From: Kimberly Ward [REDACTED]
Sent: 24 February 2021 14:09
To: Nicola Moore
Subject: Re: 1 Tarrant Street

Subject: 1 Tarrant Street

The Pea Pod, 1, Tarrant Square, Tarrant Street, Arundel, West Sussex, BN18 9DE

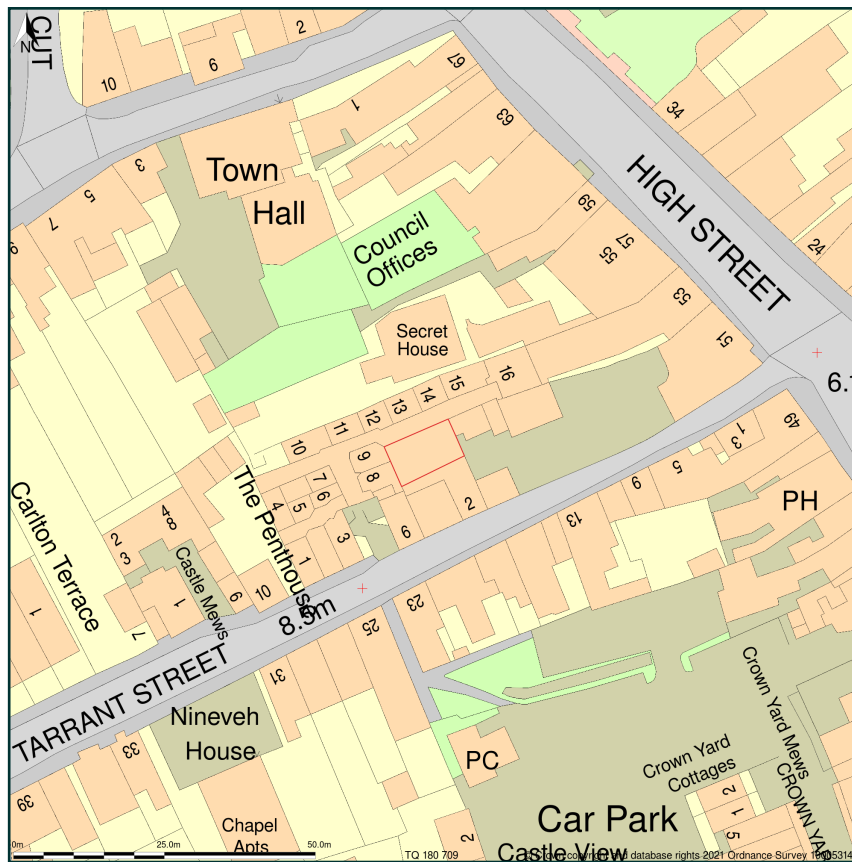
I have double checked the Location Plan, and there is no scale and direction of North. Please amend accordingly, and re send. Alternatively, you can Google 'Buy a Plan'.
